From: Yapton Parish Council Clerk [REDACTED]
Sent: 01 December 2021 11:56
To: Simon Davis <Simon.Davis@arun.gov.uk>
Subject: RE: Drove Lane Sales Cabin refs Y/141/21/PL and Y/142/21/A

The Parish Council now wishes to withdraw the Parish Council's objection to application Y/141/21/PL (*Temporary Sales Cabin & associated landscaping.....*).

With respect to application Y/142/21/A (*Various advertisements in various locations, Land East of Drove Lane, Yapton*) , the Parish Council objects on the grounds that:

"Premium" Barratt MAIN SIGN TOTEM (DOUBLE SIDED)
Prefabricated folded aluminium panel
DIRECT DIGITAL PRINT
1500mm x 4000mm

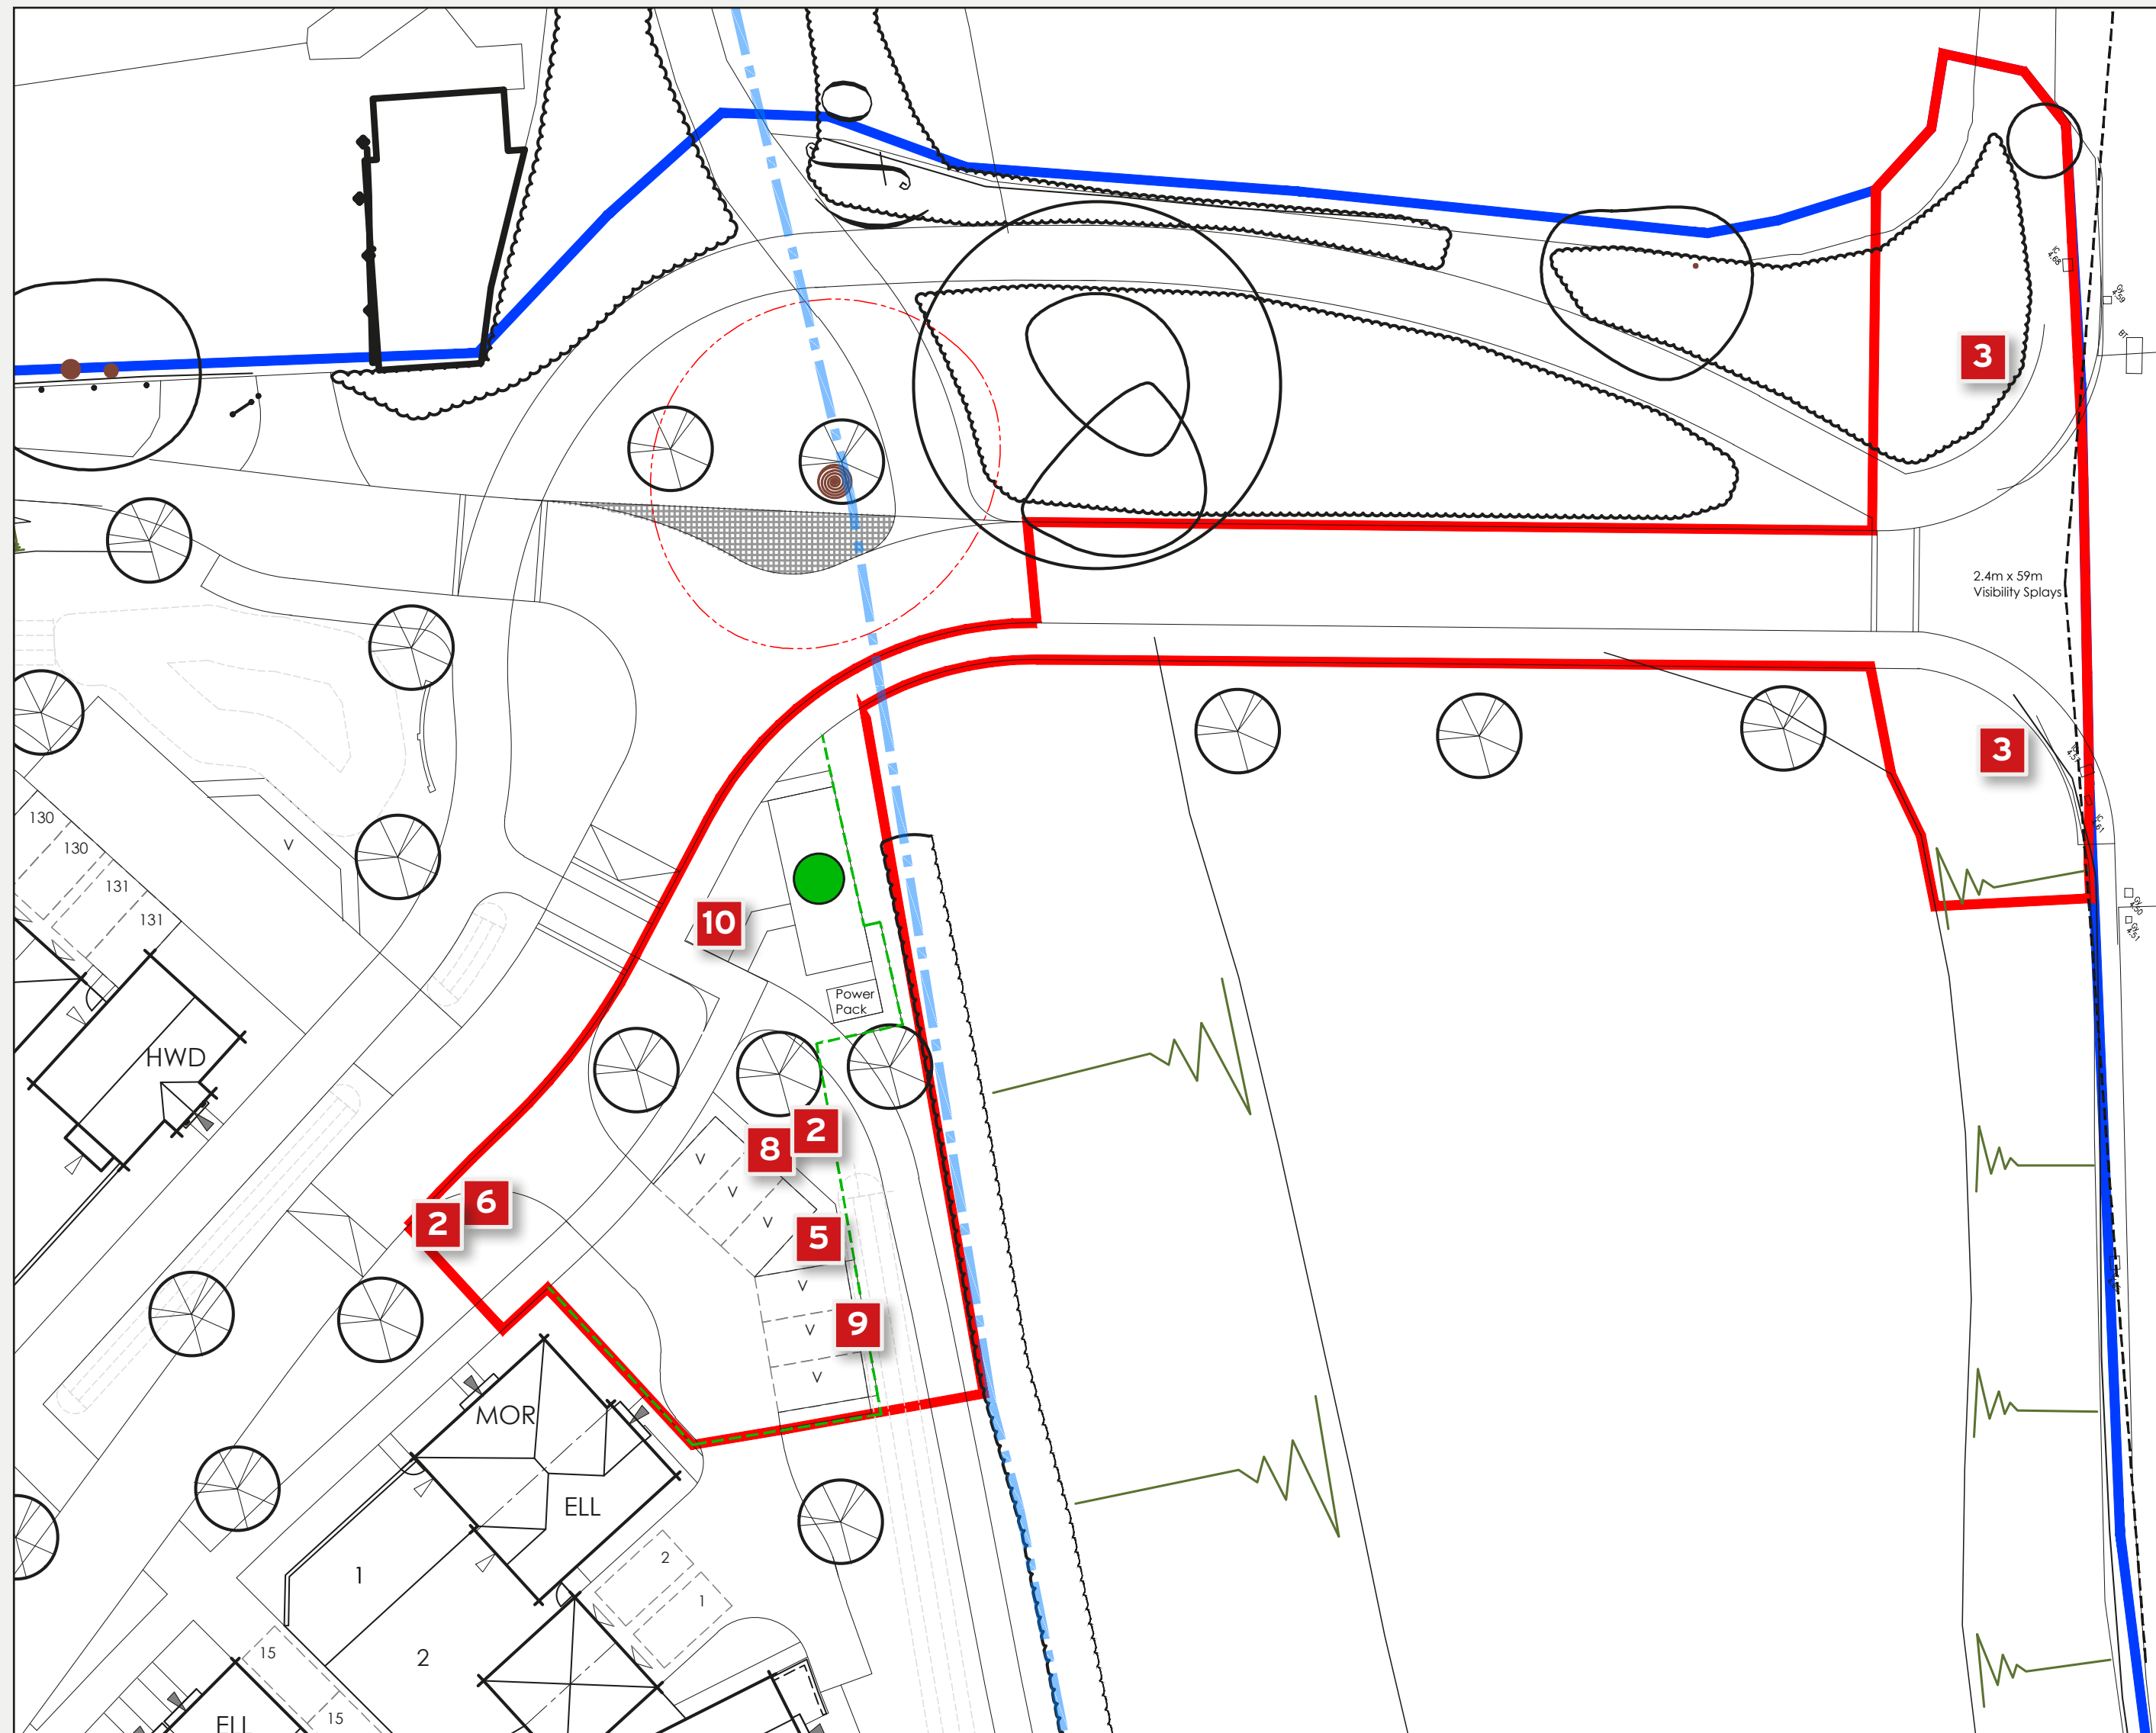
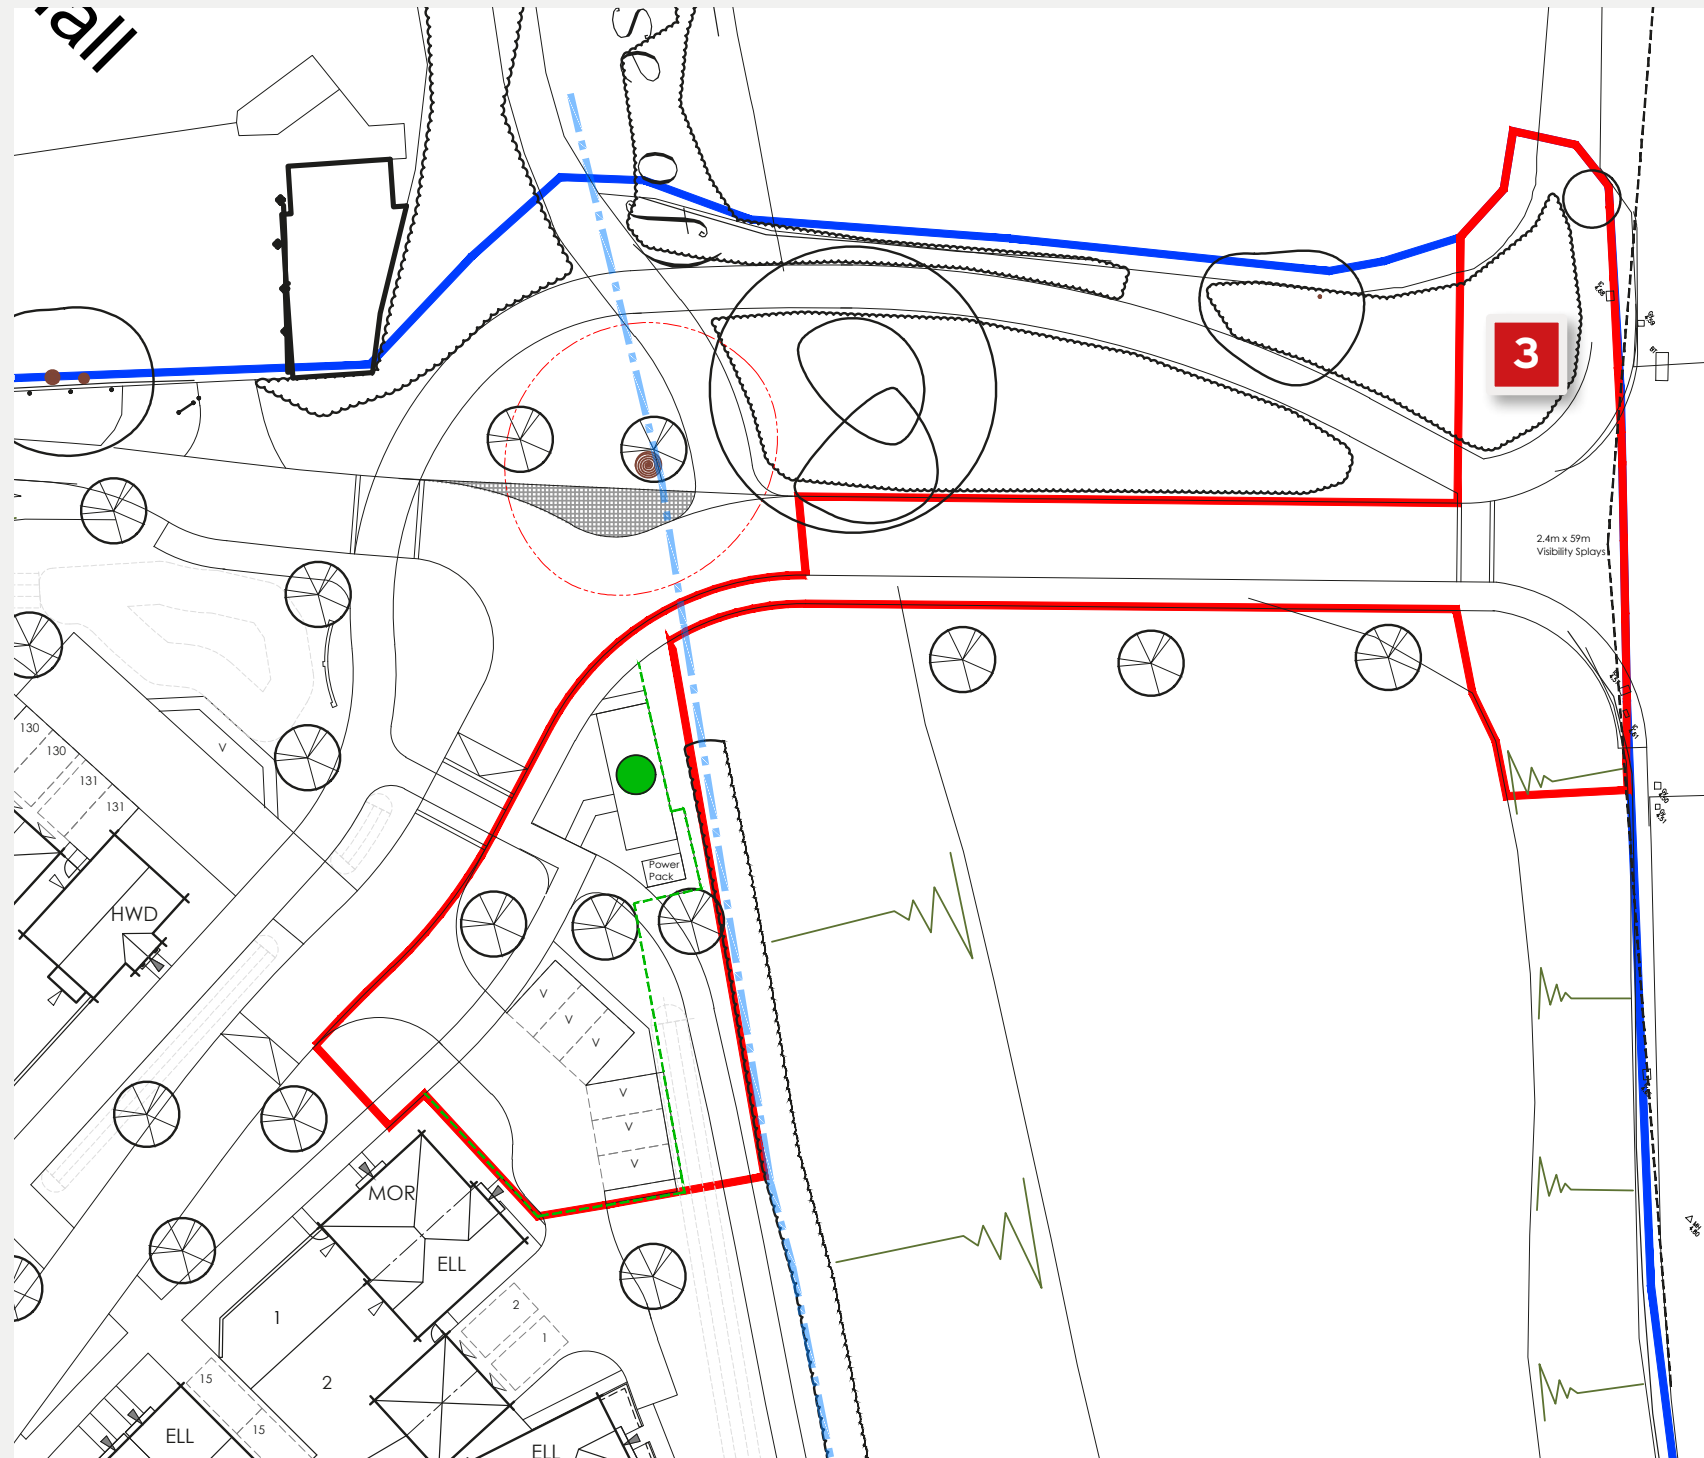
The concern is the level of signage fronting Main Road. By adding a further two 12 foot totems isn't going to remove or indeed lessen the clutter on the frontage. The Parish would strongly suggest the applicant simply has one totem and no more fronting the main road as per other house builders in Yapton. The Parish Council would request that the height restriction for the totem is no higher than 1.5m.
